Leagram Mill Farm, Leagram

TN01 – Response to Lancashire County Council Highways

Client:	Kim Weld-Blundell	Job No:	J329380
Date:	05 February 2026	File Name:	TN01
Prepared by:	LJ	Approved by:	ME

The site access will be widened, and set-back from the road with gates. A stone wall will continue to define the driveway / entrance from the front garden area of the property.

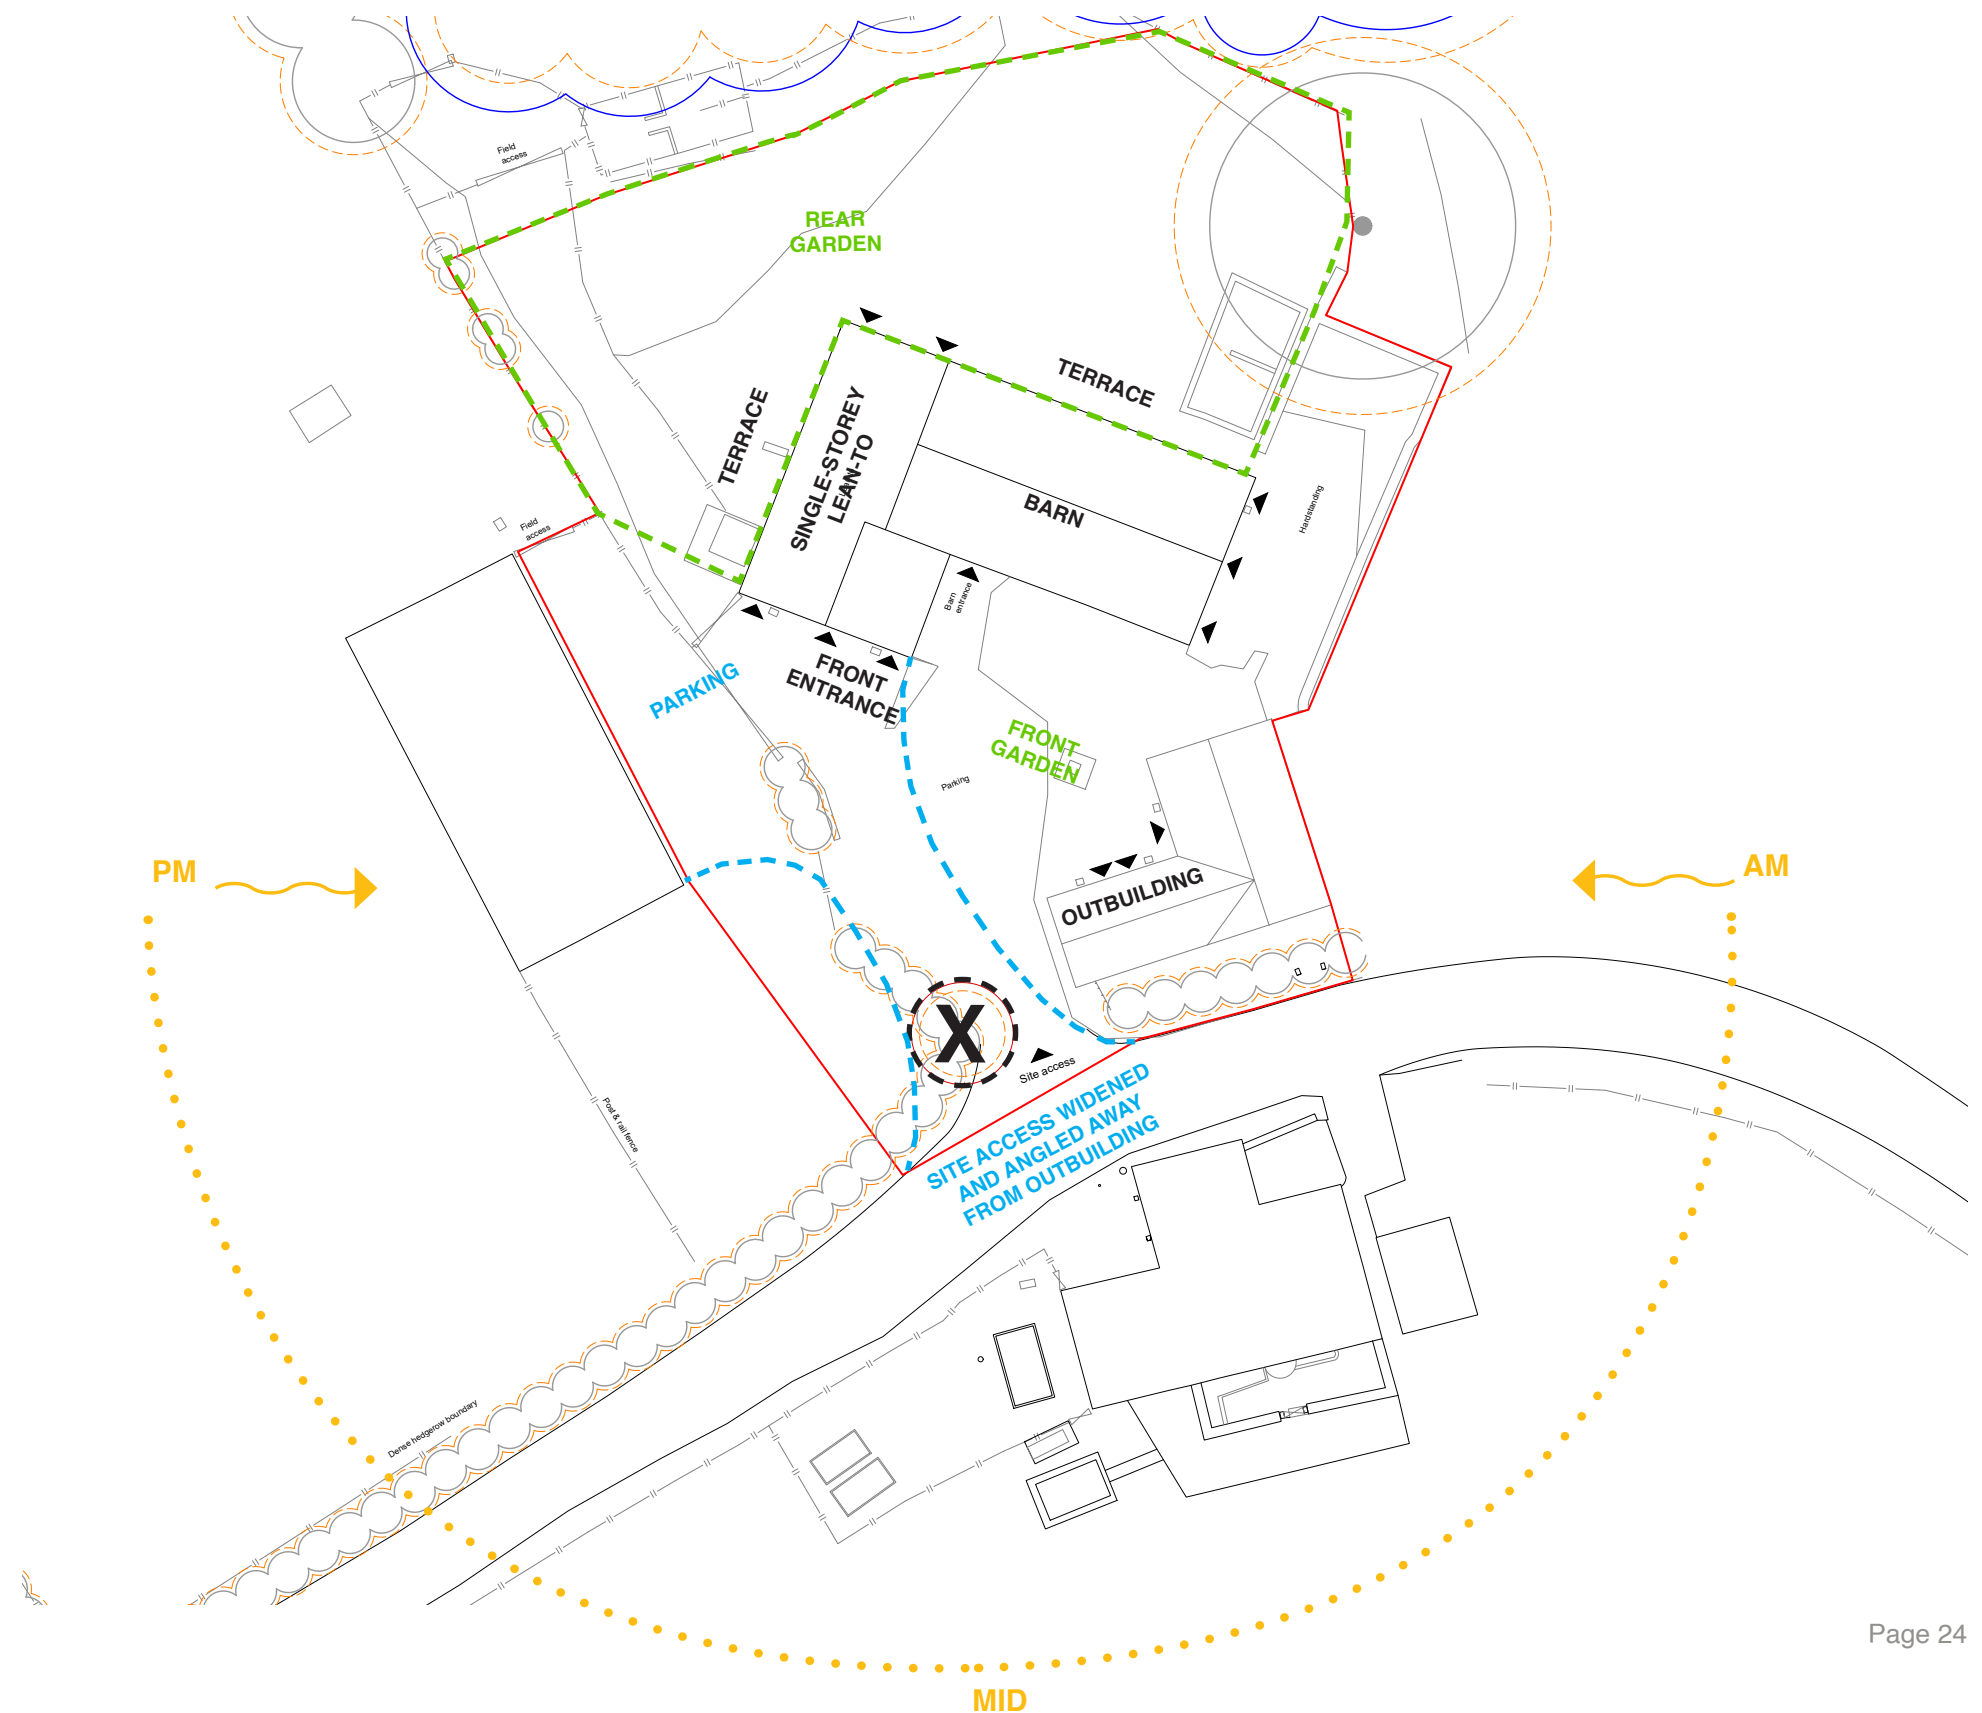
The site will be accessed via an amended existing access onto Dinkling Green Lane, classified as the C567, subject to a national speed limit. The access amendments include widening the existing access point to approximately 11m, the placement of a boundary wall around the access and gates set back approximately 9.5m.

The proposal will generate more car movements and drivers will not have the same clearance over vegetation as the existing agricultural vehicles using the site. As such to ensure adequate intervisibility between highway users at a new access a visibility splay set 2.4 metres back from the near edge of the carriageway and extending 214 metres along the nearside carriageway edge in both directions should be provided.

The visibility splay should be wholly within the land which the applicant controls and/or the adopted highway and nothing shall be erected, retained, planted and / or allowed to grow at or above a height of 0.9 metres above the nearside carriageway level which would obstruct the visibility splay of the proposed access.

Or alternatively, reduced sight lines may be acceptable if the applicant can provide an observed traffic speed study, which indicates the 85th percentile traffic speeds are less than detailed above. The traffic study would need to be carried out by an approved specialist showing the 85th percentile wet road traffic speeds in both directions, the numbers of vehicles, types of vehicles and the speed of vehicles passing the access.

The applicant should provide accurate details of the required sight line requirement, before determining the application.

Further amendments are required in regard to the access; the proposed gates should be set further back into the site at 10m behind the carriageway edge. This is because the site will provide access to an agricultural building and as such, agricultural vehicles and trailers require further space to pull clear of the carriageway. The access shall be paved in a permeable hardstanding material for 10m into the site to prevent debris from being dragged onto the highway and drainage, collected within the site and drained to a suitable internal outfall, should be provided at the access point to prevent water from discharging onto the highway.

3.2.2 Based on Manual for Streets (MfS) standards for the recorded 85th percentile speeds shown in [Table 3.1](#), visibility splays of 2.4m x 27.5m and 2.4m x 30.4m are required to the west and east respectively.

3.3.2 Based on MfS standards for the recorded 85th percentile speeds shown in [Table 3.1](#), visibility splays of 2.4m x 27.5m and 2.4m x 30.4m are achievable to the west and east respectively in land under the control of the applicant and the adopted highway. The landscaping to the west of the proposed access will not exceed 0.9m above the carriageway level. The proposed gate has been set back into the site at 10m from the carriageway edge.
